## **Submission for proposed data centre – 12 Mars Road, Lane Cove West**

### **Application Number: SSD-82052708**

We, the Lane Cove Responsible Planning Group, ***object*** to the proposed data centre at 12 Mars Road, Lane Cove West.

The Lane Cove West Responsible Planning Group had engaged consultant Acoustic Dynamics to undertake a “Noise Emission Assessment – Expert Peer Review” of the EIS for 12 Mars Road (SSD-82052708), with focus on its Appendix U – Noise Impact Assessment.

DRAWING TITLE
**GENERAL ARRANGEMENT - ROOF
 PLAN**

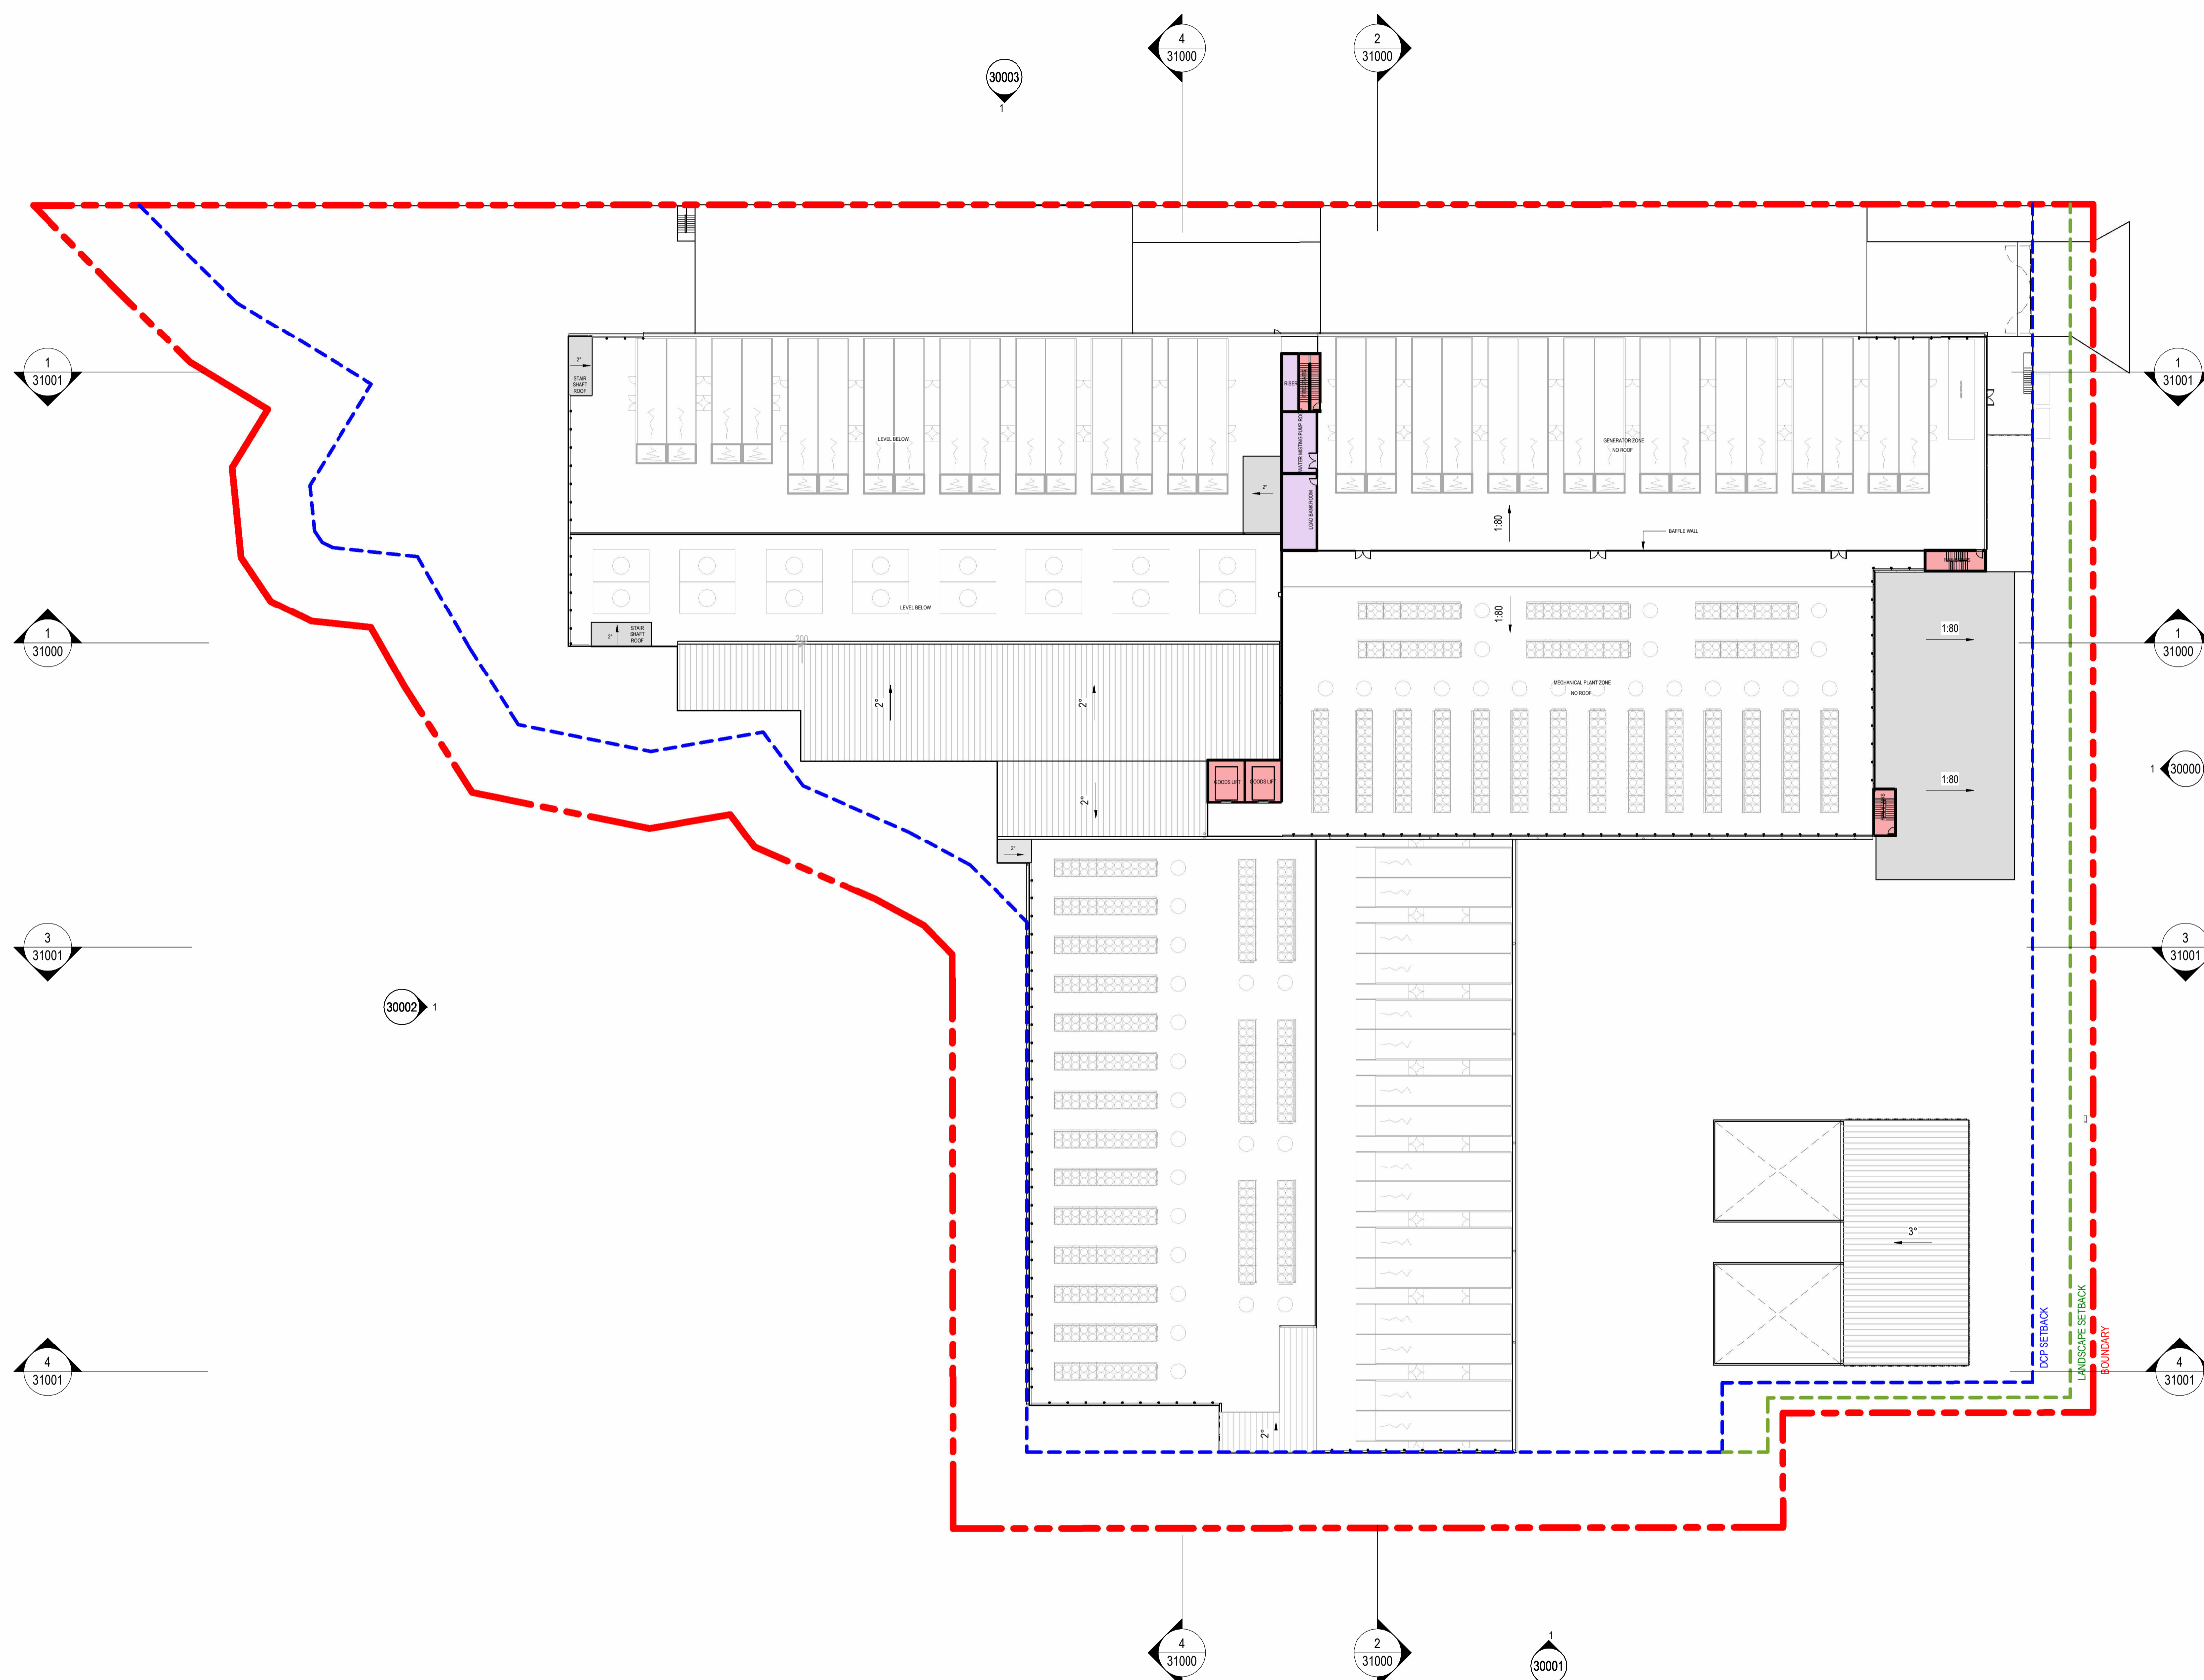
The proposed development is not a conventional warehouse or low-impact industrial use. It is a large-scale, 24-hour, 7-day-per-week data centre involving substantial mechanical plant, 49 rooftop back-up emergency generators, eight cooling towers, two load banks, 40 air-cooled chillers, electrical substations and associated plant. The development is located close to established residential receivers, including homes near Banksia Close, Wood Street and surrounding streets.

The proposal relies on a large number of emergency generators. Acoustic Dynamics notes that the generator sound power levels are based on design assumptions and that the generator enclosures are presumably yet to be designed and constructed. The peer review also states that breakout noise through the generator enclosure itself should be considered, and that a “shipping container style” enclosure is likely to be insufficient to adequately mitigate generator breakout noise.

These are not minor matters. Generator noise and internal data hall breakout noise are central to the acoustic risk profile of the development. They should be fully assessed before approval, not deferred to later design stages.

6. Require complete assessment of emergency generator noise, including enclosure breakout, start-up noise, full-load operation and exhaust noise.
7. Require assessment of internal data hall breakout noise and building façade transmission.
